Rezoning Transportation Analysis

Petition Number: 2020-160

General Location Identifier: Tax ID 10102101

Revision Log:	Date	Description
	12-28-20	First Review (WB)

**Aldersgate Rezoning #2020-\_\_\_**  
3800 Shamrock Drive  
Charlotte, NC 28215  
Date: 10/02/2020 Rezoning Submittal  
Project ID: 17048  
**Proposed Rezoning Technical Plan**  
**RZ-01**

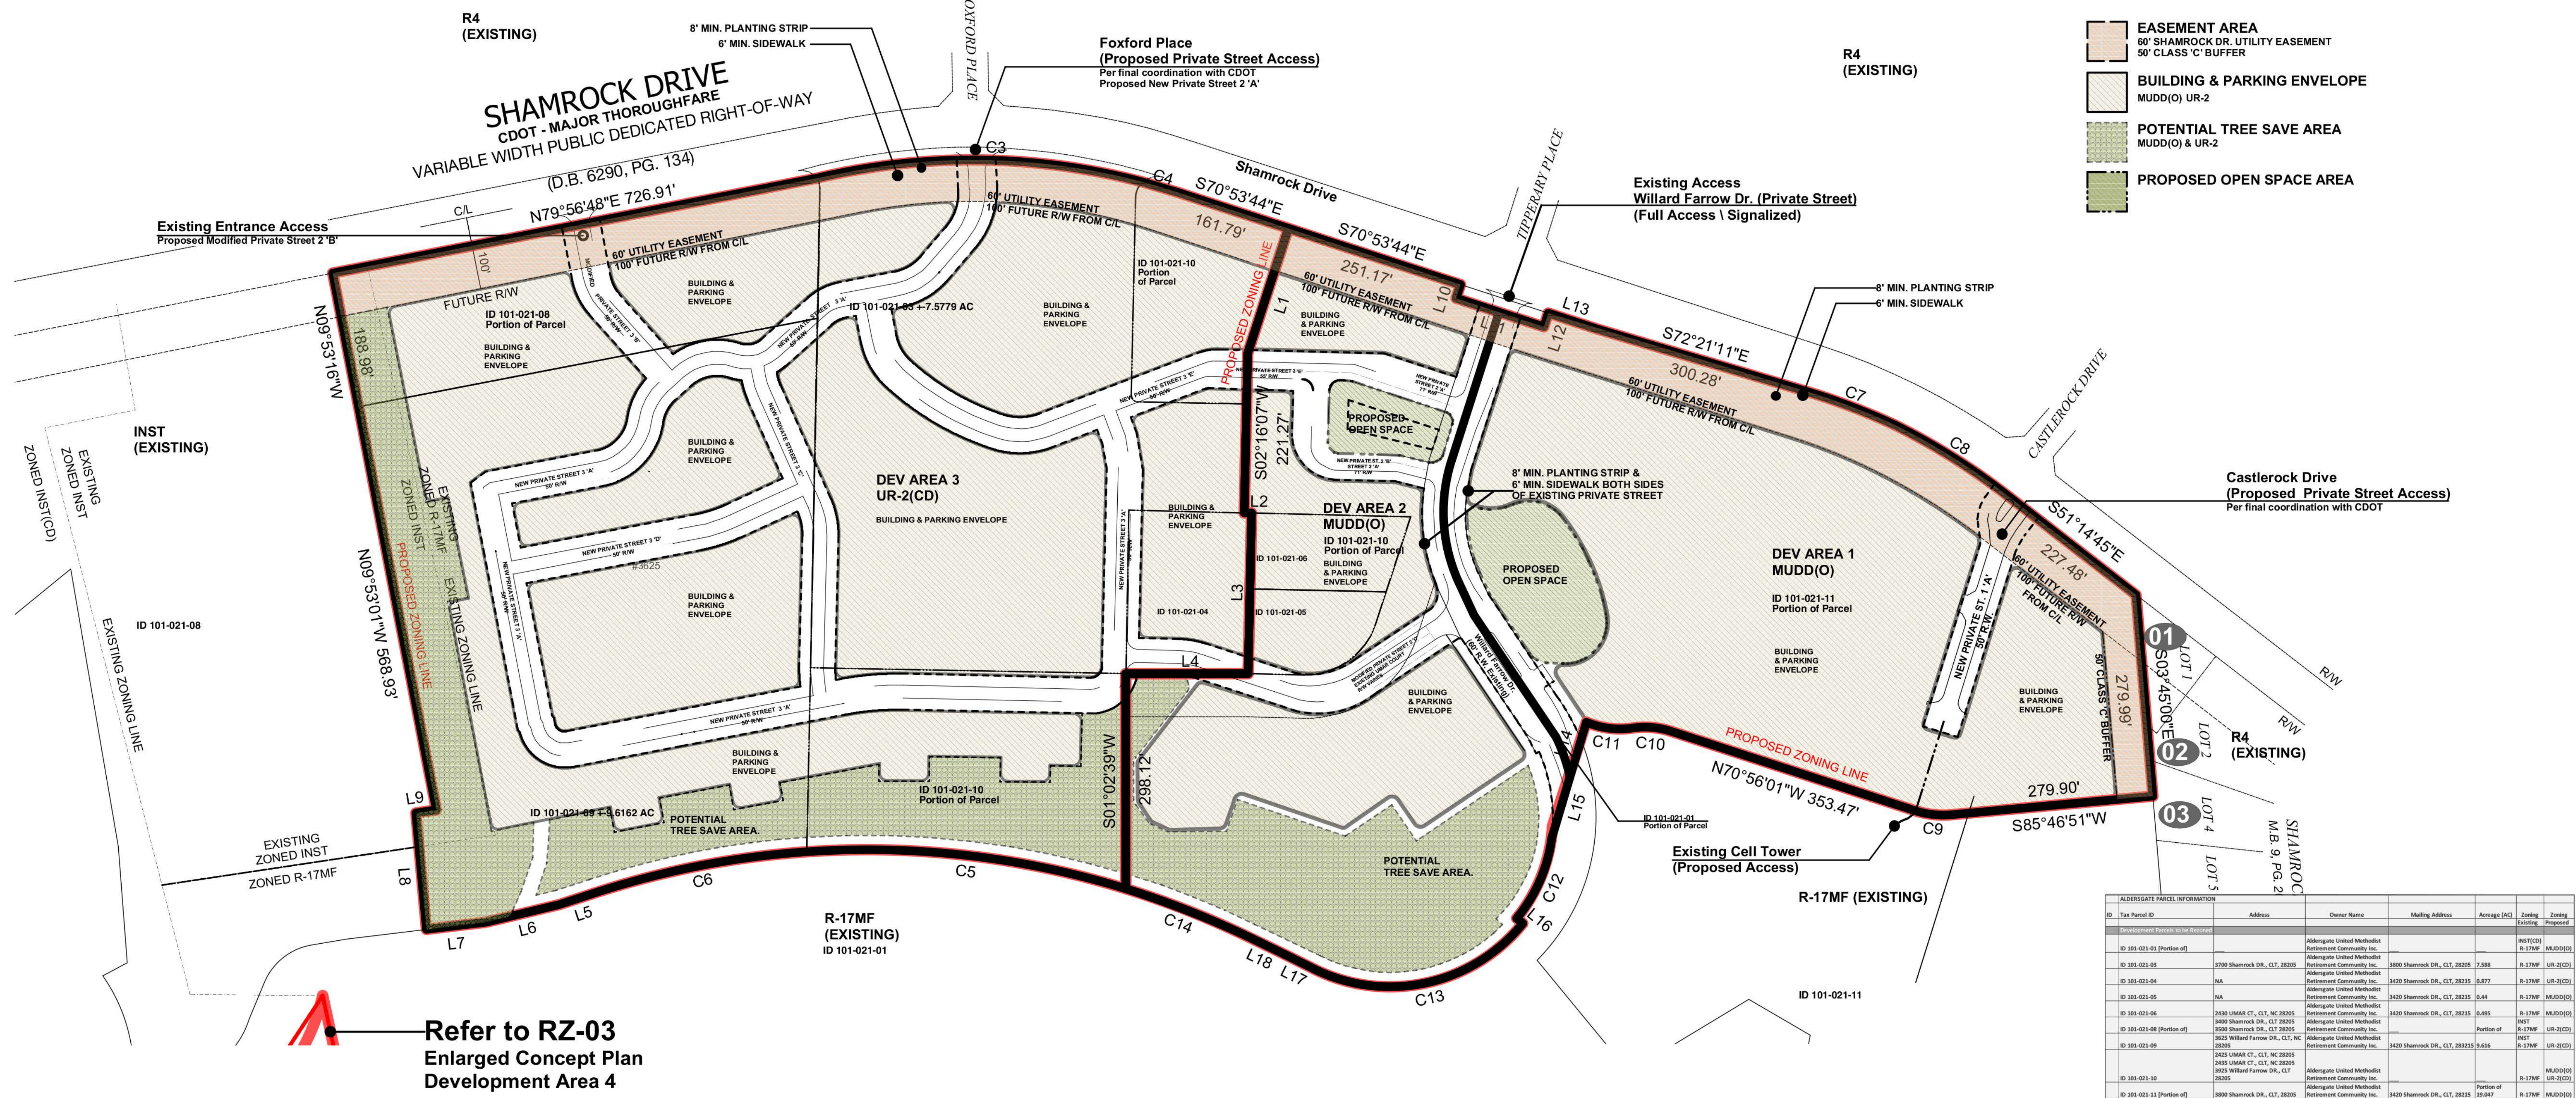
Label and dimension the back of curb and gutter from the Shamrock Drive centerline.

2. Revise site plan and conditional note(s) to commit to dedicating 50-feet of right-of-way (minimum) from the Shamrock Drive centerline. Label and dimension the right-of-way from the road centerline.
3. Revise site plan and conditional note(s) to commit to providing pedestrian and bicycle access through the site, from two existing public street stubs (Dowling Drive and Seaforth Drive) and the Edsel Place cul-de-sac, to Eastway Drive, Shamrock Drive and the Briar Creek Greenway. The pedestrian and bicycle connectivity is consistent with the Eastland Area Plan recommendations, the Charlotte BIKES Policy and the Charlotte WALKS Policy.

Add a conditional note stating that “Pedestrian and Bicycle access to and from Parcel 10102101 by the way of Dowling Drive, Seaforth Drive and Edsel Place, shall be provided.”
